Your ref: 3/2022/0954

Date: 9th November 2022

**Listed Building Application 3/2022/0954: Listed Building Consent for a proposed single storey extension and new rear entrance canopy.
Waddington New Hall, Edisford Road, Waddington**

PROPOSED GROUND FLOOR PLAN SCALE 1:100

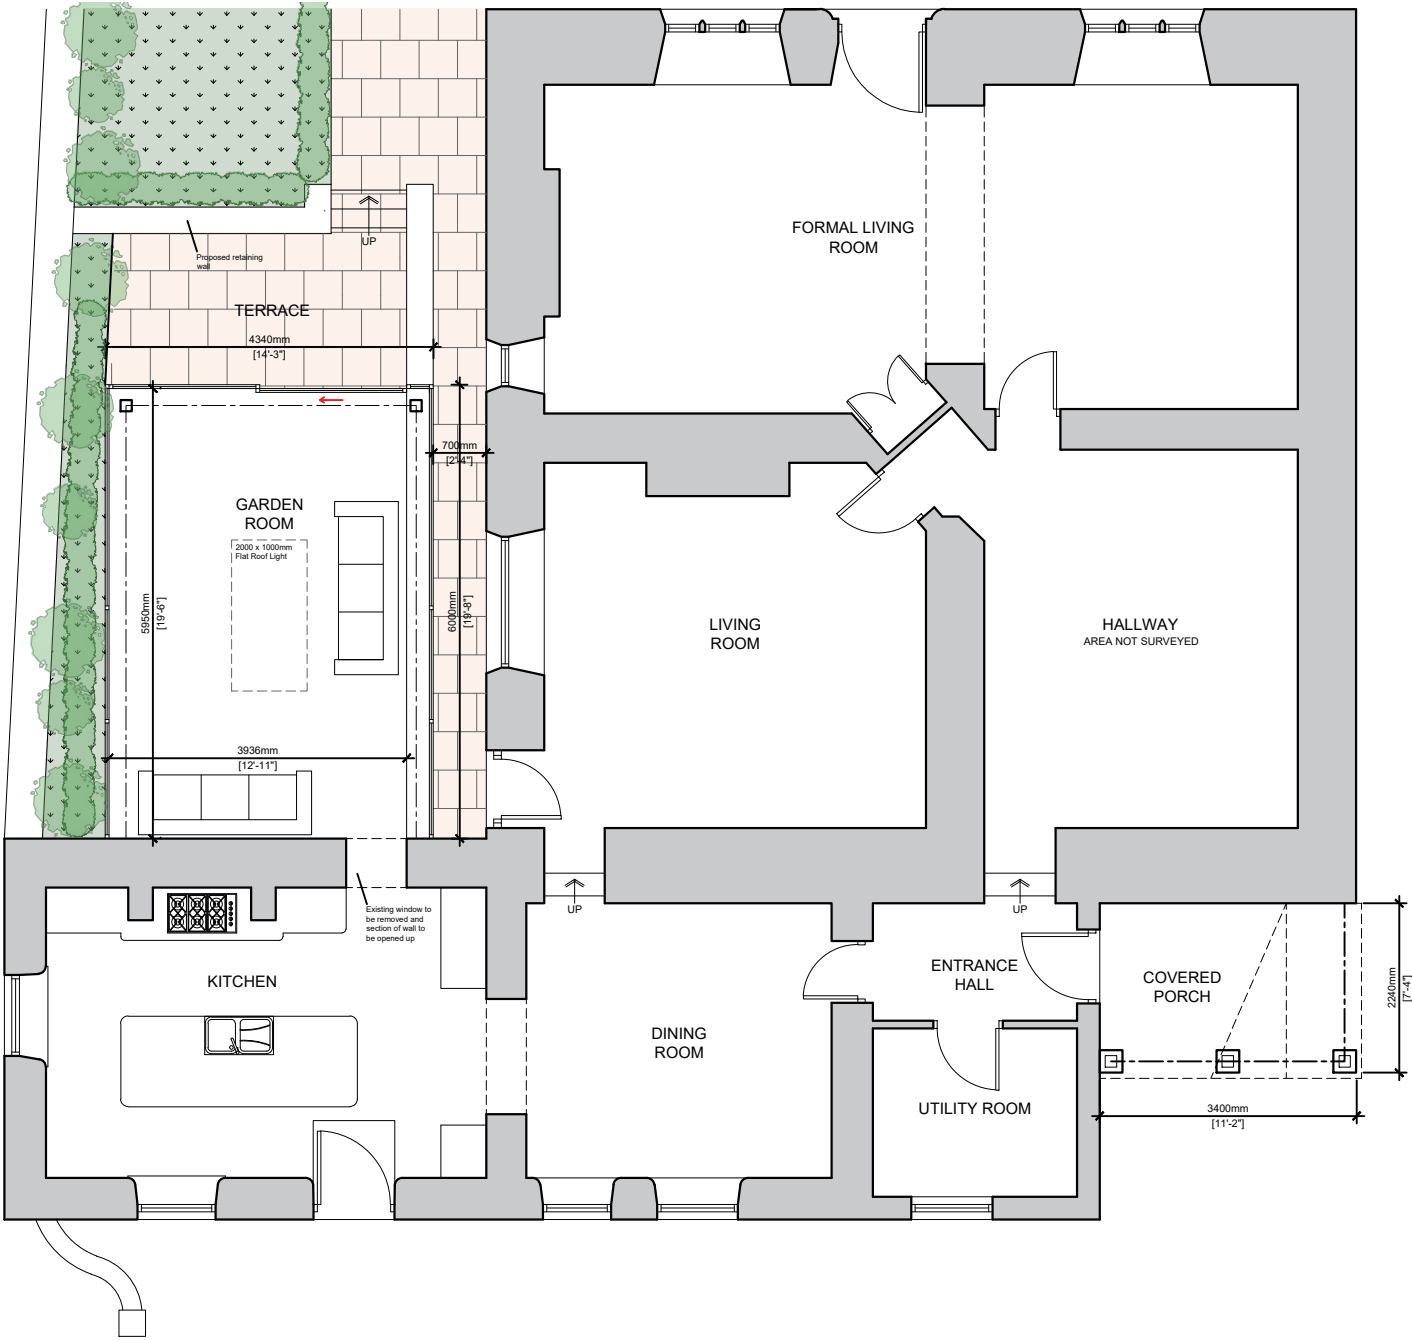
We would accept that the main impact on the historic fabric of the existing building is to what appears to be an early 19th century extension on the north and east corner of an earlier house. The extension appears to be marked on the OS 1:10,560 map of 1850 (sheet Yorkshire 182, surveyed 1847), which is the earliest map of the settlement we have access to, and may be related to the purchase in 1810 by Robert Walker, although as noted by the HS the scale of the mapping makes such a judgement difficult. The proposed extension will mask views of the ground floor windows on the east side of the main house, but will not physically impact them. There will also be, as noted, an impact of the setting of the house and the conservation area by the roof and upper portions of the extension visible above the roadside wall. The proposed new porch canopy will partially obstruct views of a further mullioned window and a door, but these are on an elevation which does not appear to be directly visible from public land.

Given the above, we would not object to the proposed development and are happy to leave judgement on the acceptability of the setting and townscape issues to the Council. Should the application be given consent we would recommend that conditions be imposed requiring (i) a photographic record of the exterior elevations impacted or partially obscured by the works (i.e. NW corner, S and E elevations); and (ii) an archaeological watching brief during (a) the opening-up of the window to form a new

- (i) A photographic record of the exterior elevations of Waddington New Hall affected by the permitted alterations, including the northwest corner by the canopy and the east elevation and southern facing return by the extension; and
- (ii) An archaeological watching brief during the opening-up of the window to form a new door and all groundworks required for the permitted development.

Condition: No works to the application building(s), including any clearance/demolition or preparation works shall take place until the applicant, or their agent or successors in title, has secured the implementation of a programme of archaeological works in accordance with a written scheme of investigation, which shall first have been submitted to and agreed in writing by the Local Planning Authority. These works should include:
